MEMO

27 July 2020

RE: MPW Stage 3 (SSD 10431)—Response to Nell and Paul van den Bos Submission

Figure 5: Network Traffic Volumes, with MPW S2 - Scenario 2

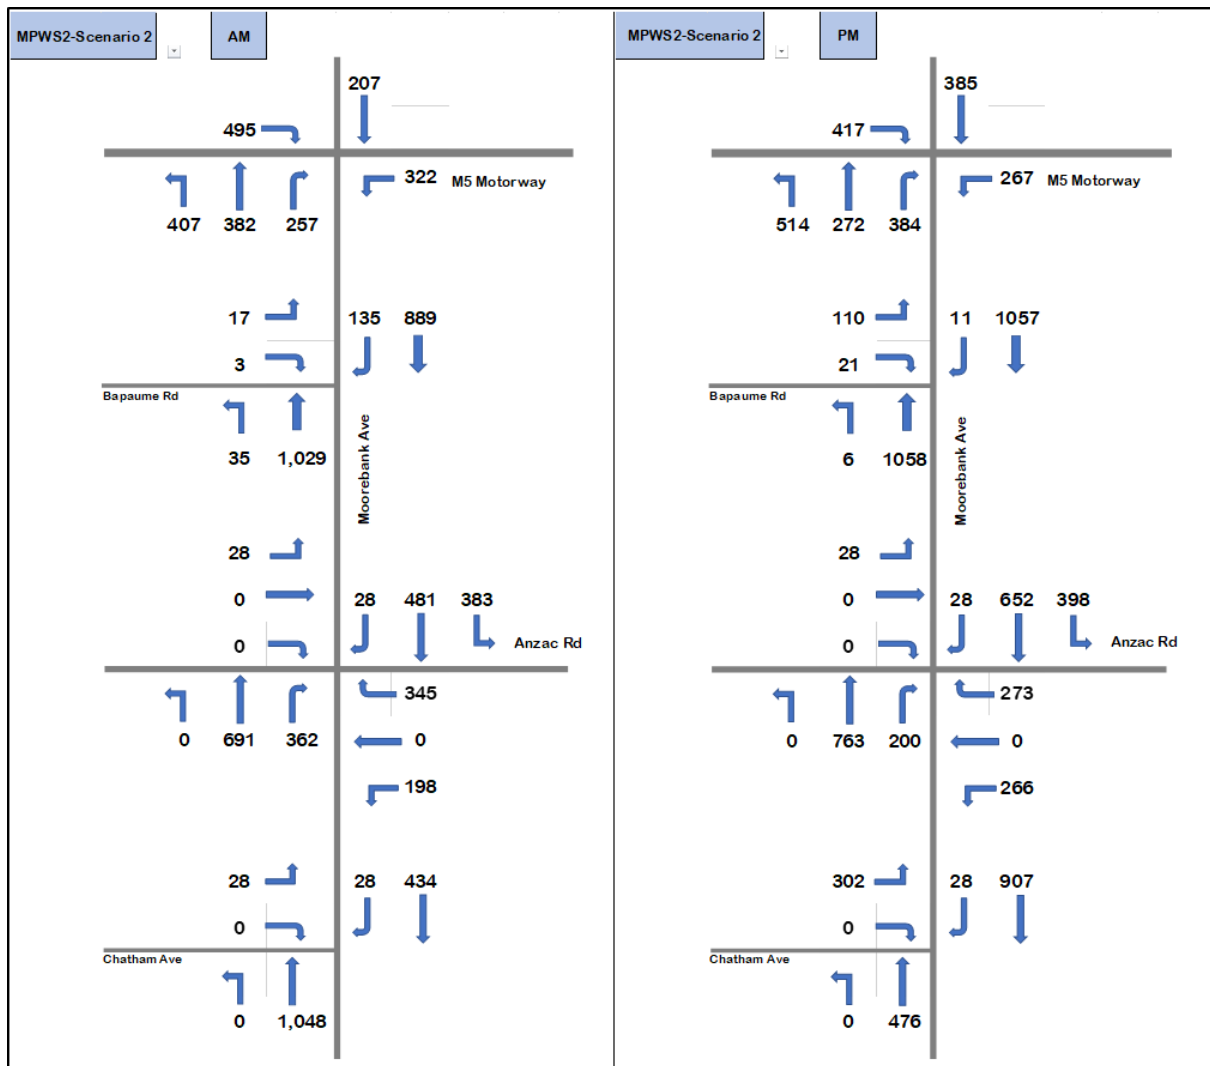
The van den Bos submission questions the change in link volumes between the intersections of Anzac Road and Chatham Avenue in Figure 5 of the submitted (April 2020).

As outlined above, that figure is provided for context only and does not replicate the MPE IMEX / JLU access from the Arcadis figures, hence there is actually an intersection between whereby some traffic may naturally ‘disappear’ from the network.

However, the submission has failed to realise that there are substantial accesses between Anzac Rd and Chatham Ave whereby this occurs. Refer below highlighted intersection from the original Arcadis figures.
